3 July 2020

**RE: BAIADA INTEGRATED POULTRY PROCESSING FACILITY (SSD 9394) – RESPONSE TO SUBMISSIONS**

Figure 8. Threatened ecological communities

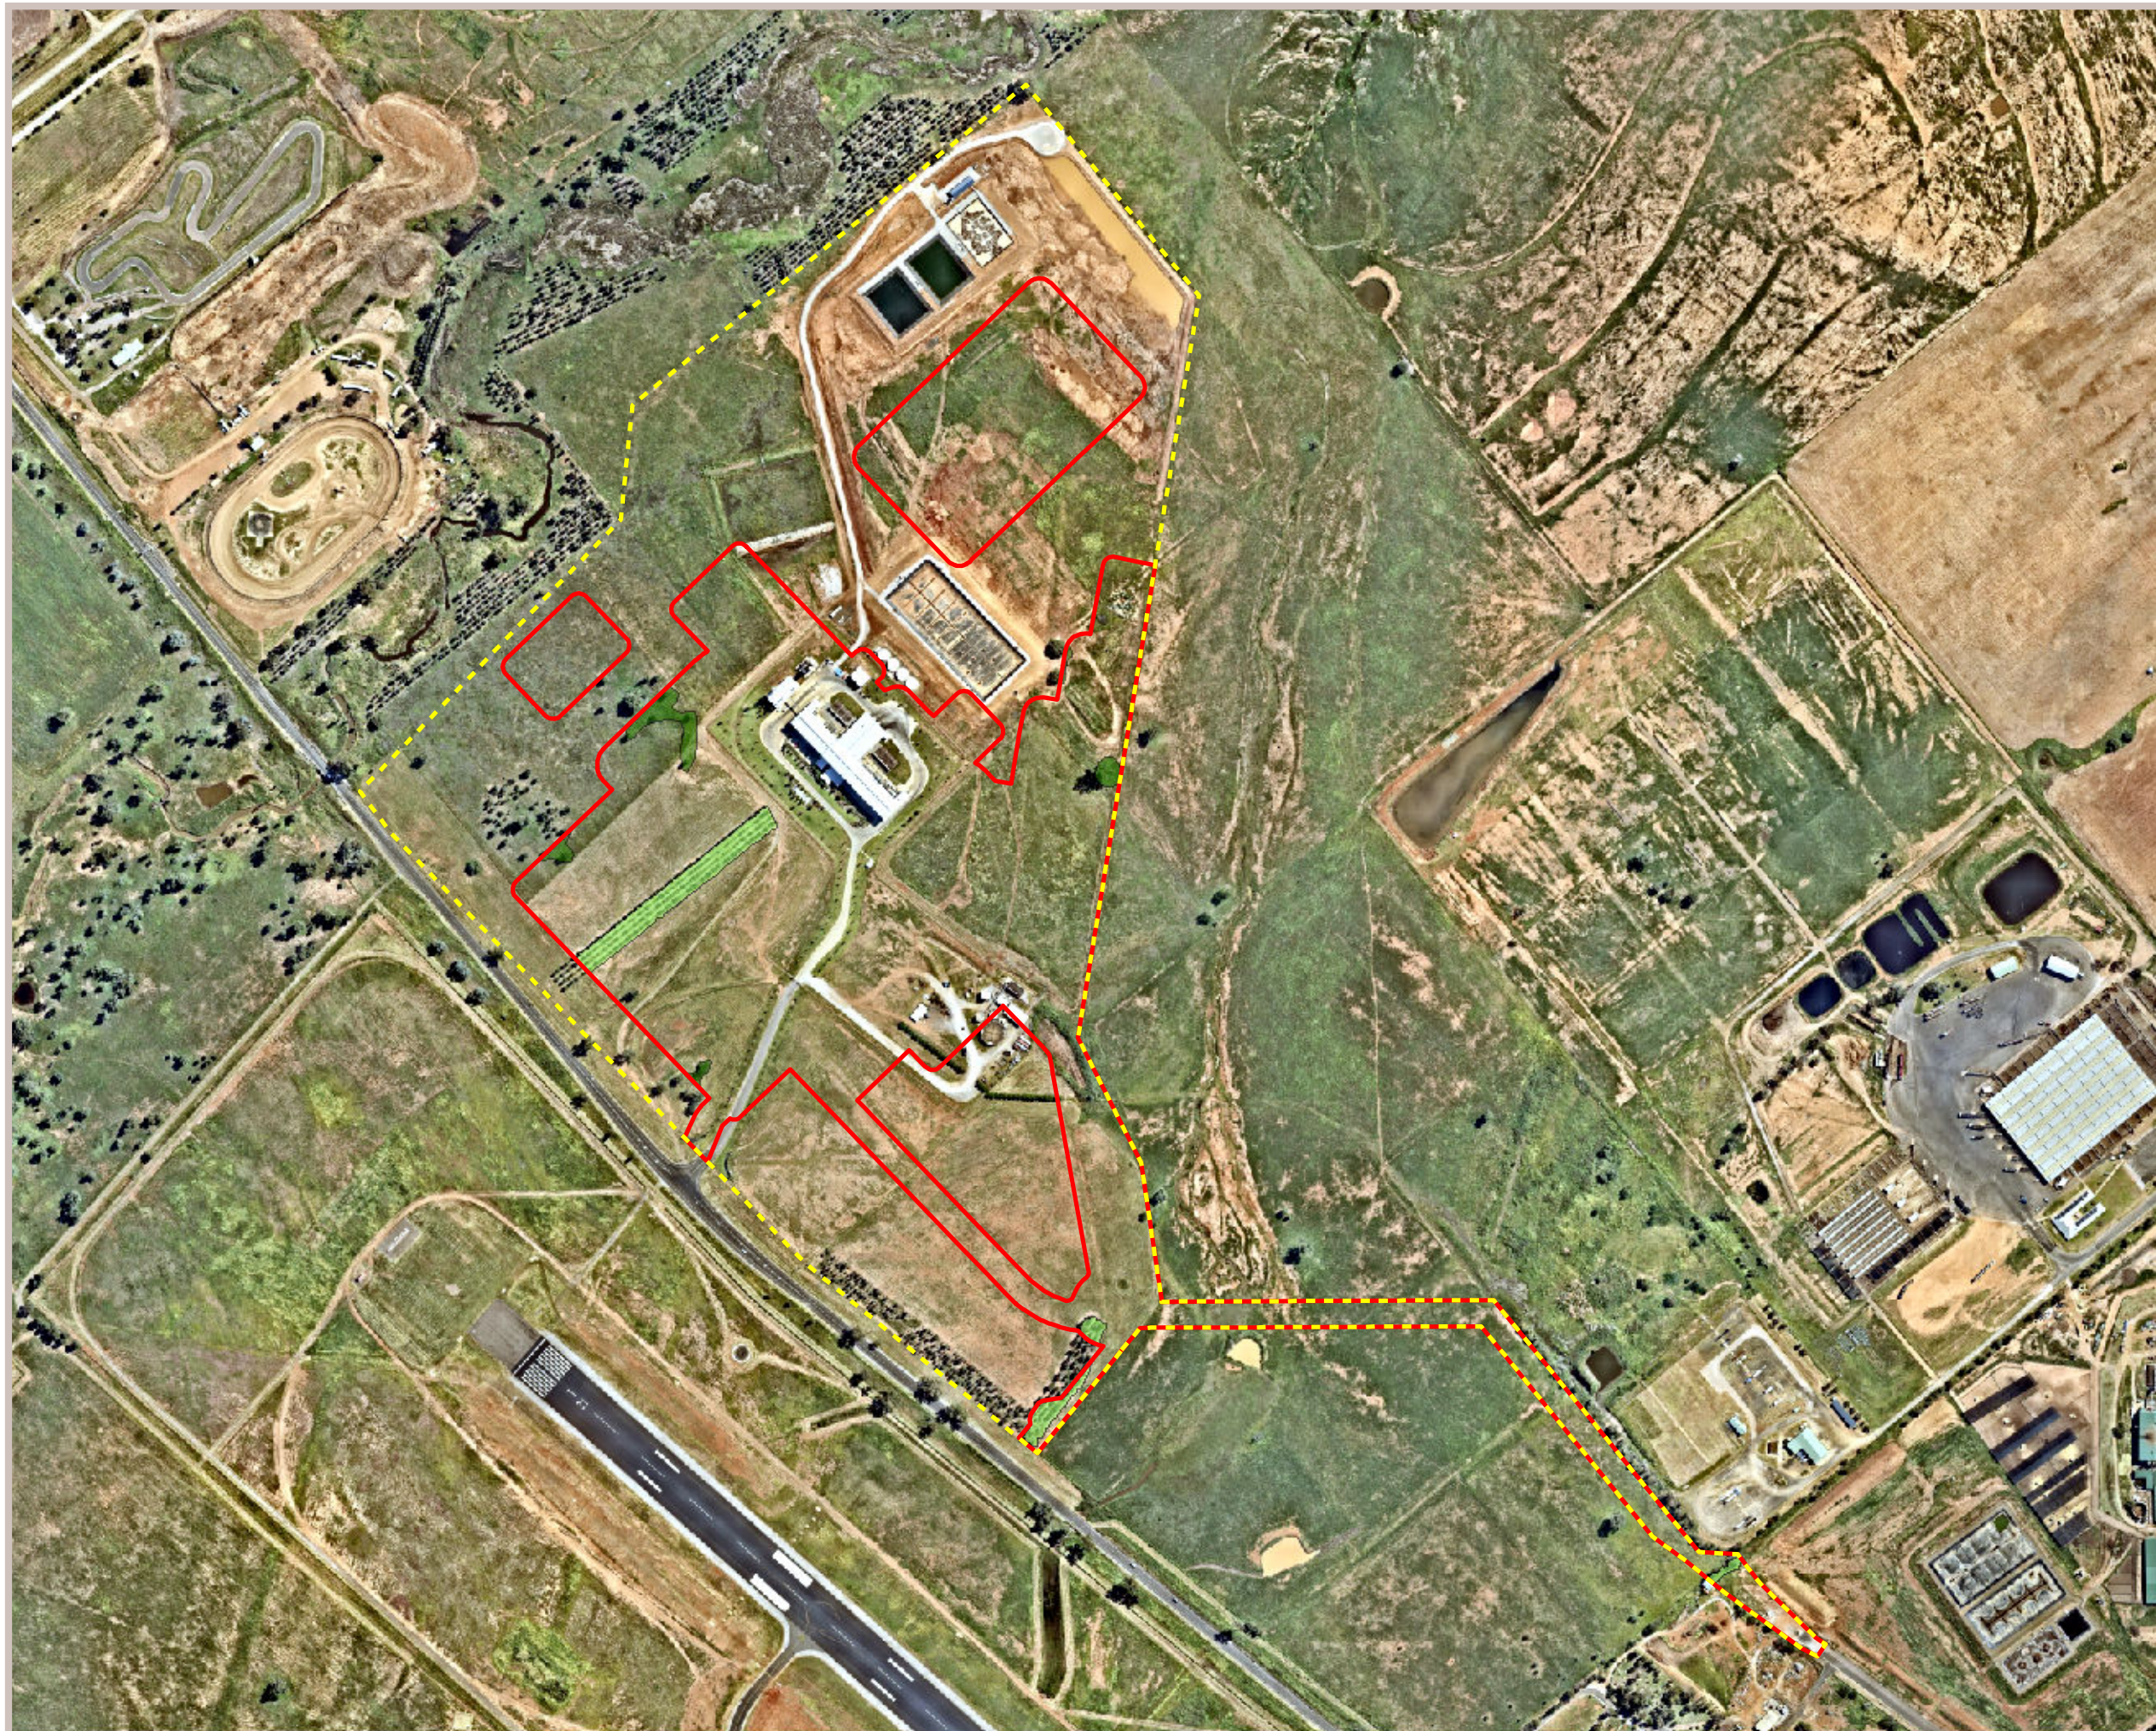
<p><b>Biodiversity offset</b></p> <p><i>The Biodiversity Development Assessment Report (BDAR) has been prepared in accordance with the Biodiversity Assessment Method.</i></p> <p><i>The proposed facility would require clearing of a total of 1.34 hectares of Blakely's Red Gum – Yellow Box grassy tall woodland on flats and hills in the Brigalow Belt South Bioregion and Nandewar Bioregion (PCT 599). Two condition states for PCT 599 were identified:</i></p> <ol style="list-style-type: none"> <li><i>1. Remnant patches – a total of 0.83 hectares would be impacted by the proposal. This community conforms to the threatened ecological community (TEC) White Box – Yellow Box – Blakely's Red Gum.</i></li> <li><i>2. Planted trees – a total of 0.51 hectares would be impacted by the proposal. This community does not conform to the TEC.</i></li> </ol>	<p>In response to the revised design, an amended Biodiversity Development Assessment Report (BDAR) has been prepared. The revised BDAR is attached in <b>Attachment 9</b>.</p> <p>The revised development plans will have a direct impact on:</p> <ul style="list-style-type: none"> <li>• Approximately 0.31ha of the 1.19 ha of the Box Gum Woodland TEC; and</li> <li>• Approximately 0.68 ha of the 1.45ha of the planted natives (screening buffer) on the site.</li> </ul> <p>The remaining ~0.88 ha and ~0.77 ha, respectively, will be retained on site. As shown in the following Table, the direct impacts on the TEC been reduced as a result of the revised building footprint, while there has been a slightly greater</p>

Previous design	Current design
Impact on Box Gum Woodland TEC	0.83 ha of Box Gum Woodland TEC	0.31 ha of Box Gum Woodland TEC
Impact on Planted Natives	0.51 ha of the 1.45 ha Planted Natives	0.68 ha of the ~1.45 ha of the Planted Natives

As a result of the removal of native vegetation, offsets are required to be paid in the form of ecosystem credits. The revised BDAR assessment indicates that the development requires a total of 15 ecosystem credits for PCT 599. A suite of other PCTs could be utilised to offset this PCT under the offset rules.
